RE: Cherry Creek Crossing Lot 111 Grading and Erosion Control Plan, El Paso County, Colorado (Kiowa Project No. 14028)

CDR-17-003 Cherry Creek Crossing Grading and Erosion Control Plan Review 1

Grading and Erosion Control Plans

OVERLOT GRADING & EROSION CONTROL PLAN

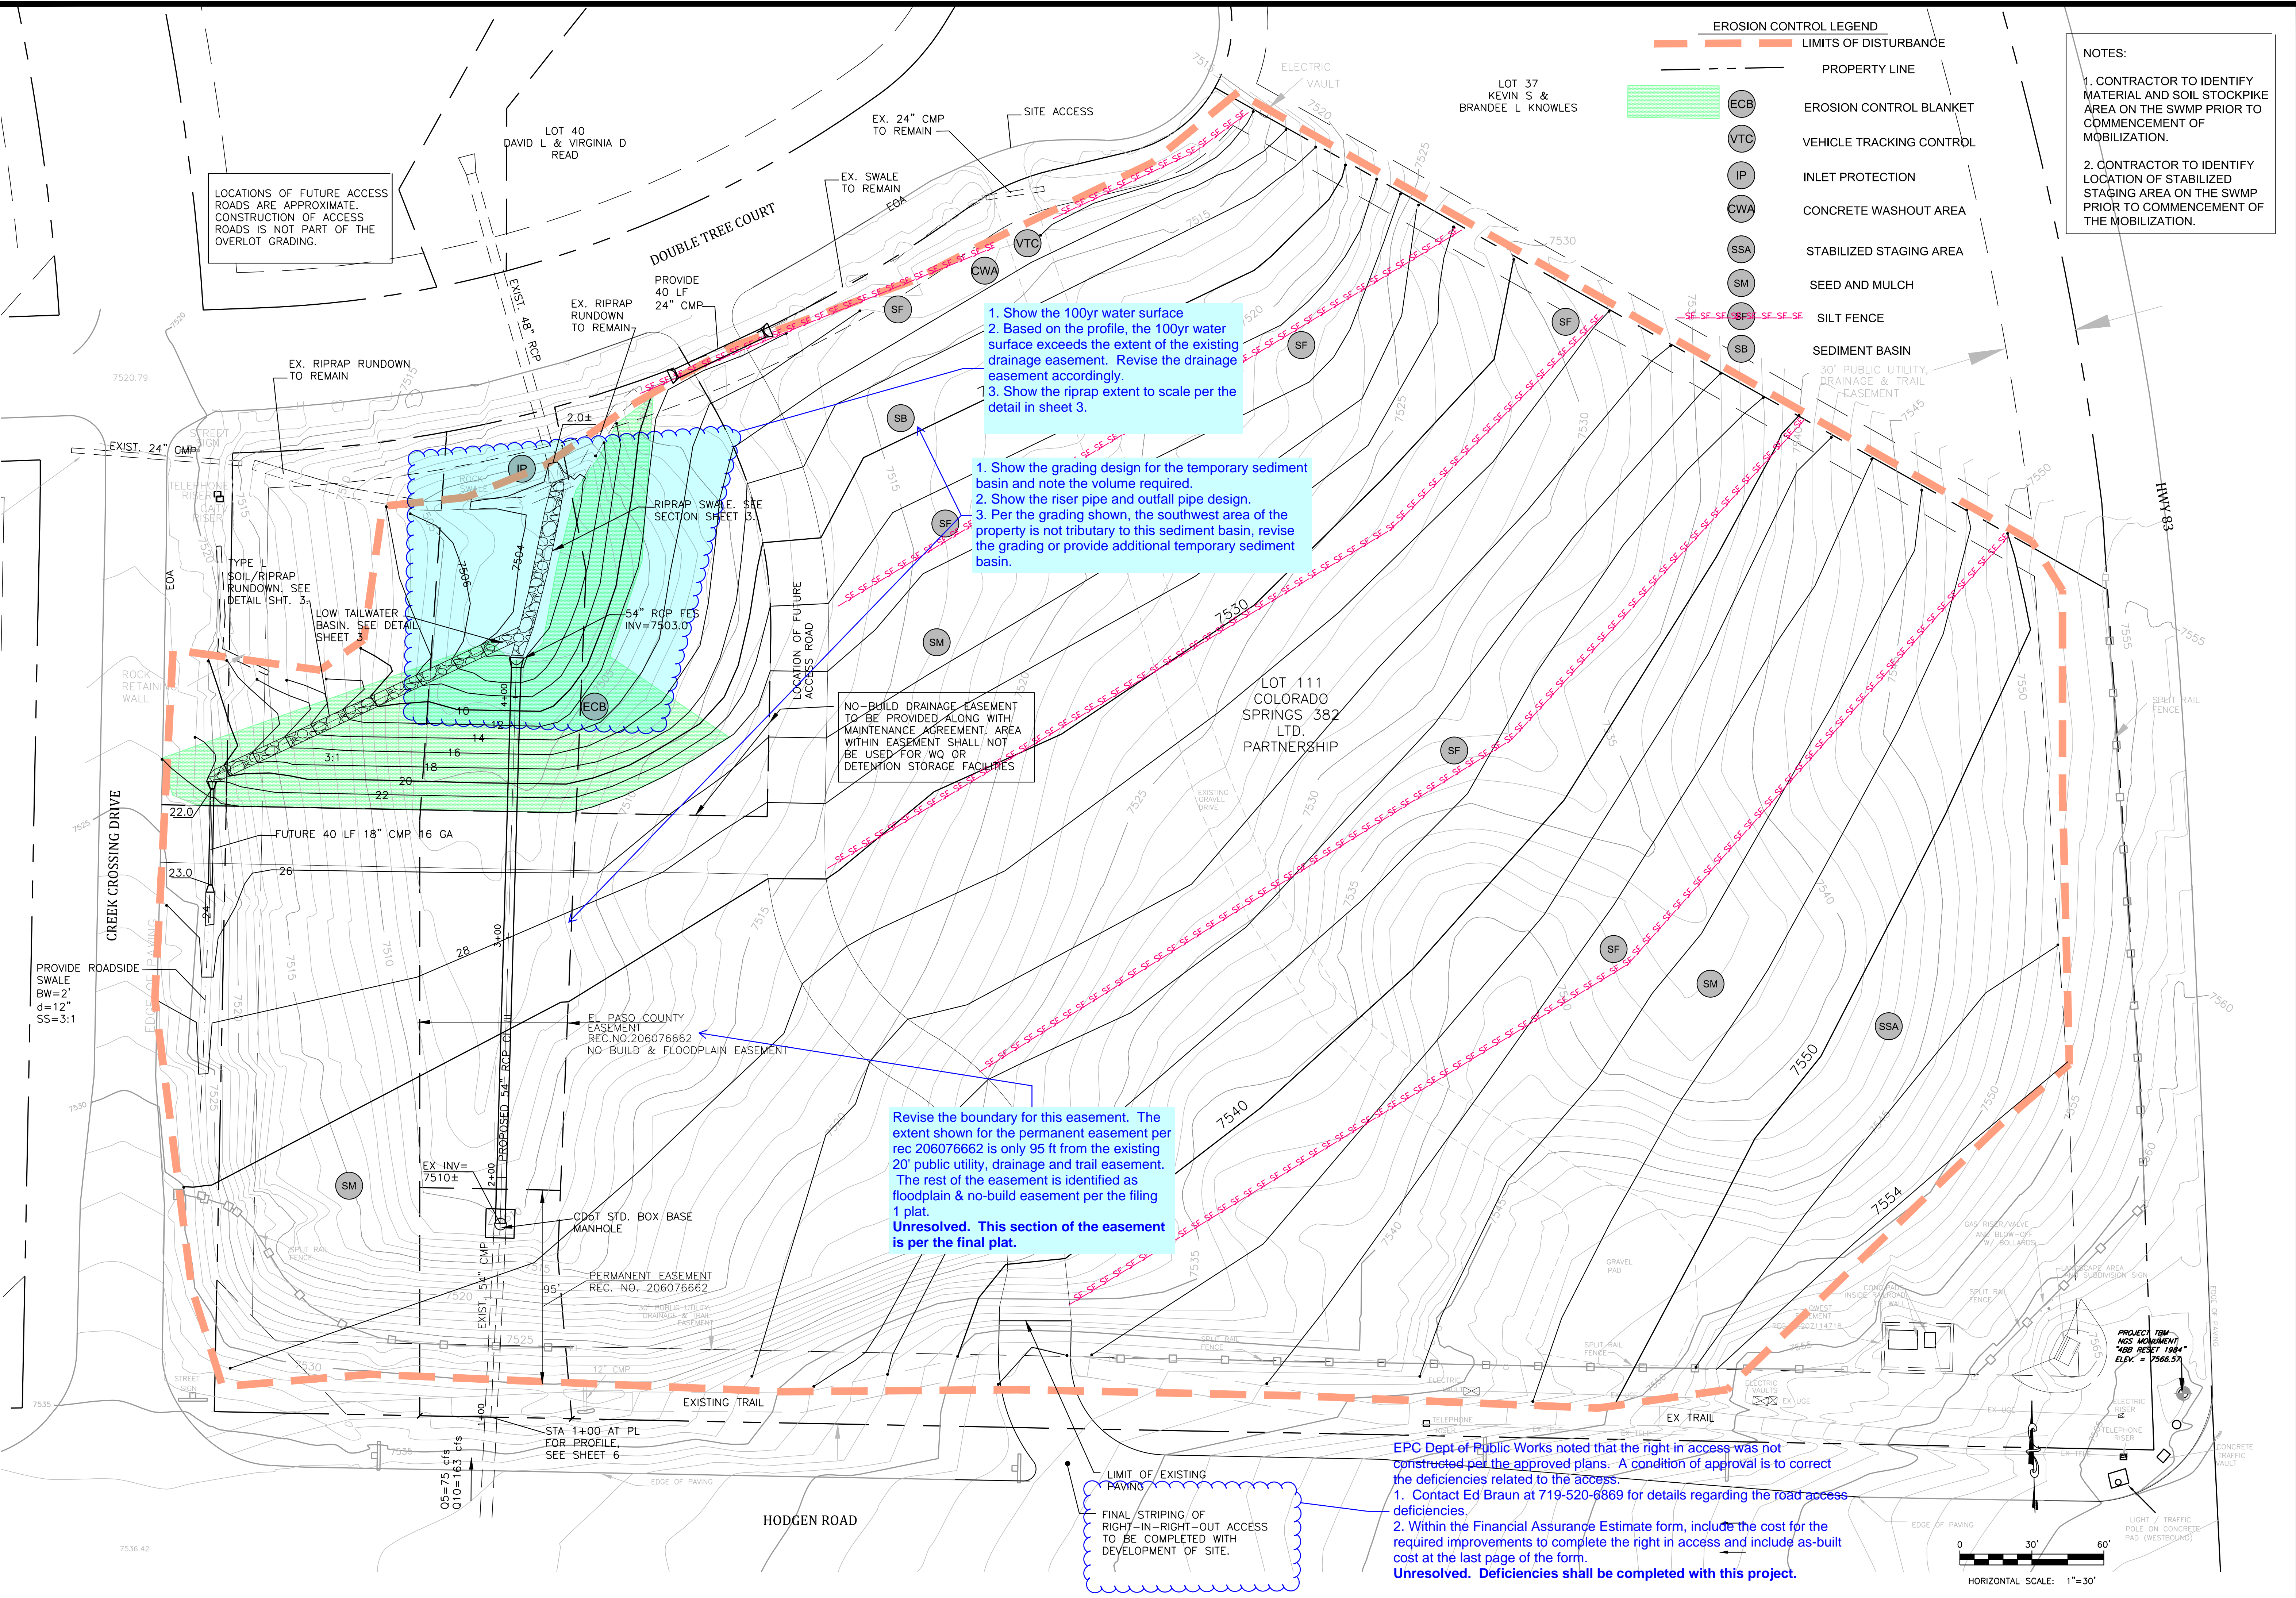
1. Reviewer requested that culverts be placed under the future access drives that were shown on this sheet. Applicant would request that the installation of culvert and roadside swales associated with future access drives be delayed until such time a specific site plan is developed.

2. Reviewer requested that an easement be provided around the area bounded by the future access drives, Creek Crossing Drive and Double Tree Court. Applicant would request that the creation and recordation of this easement be delayed until such time a specific site plan is developed.

3. Reviewer requested that the striping associated with the right-in/right-out off Hodgen Road not finished when the access was built in 2016 be completed as part of this project. Reviewer asked that we contact Mr. Ed Braun at EPC. Contact with Ed was made. As a result of our contact with Ed, the applicant would request that the striping be completed when the site moves into final site development. The entrance is now barricaded and will remain barricaded.
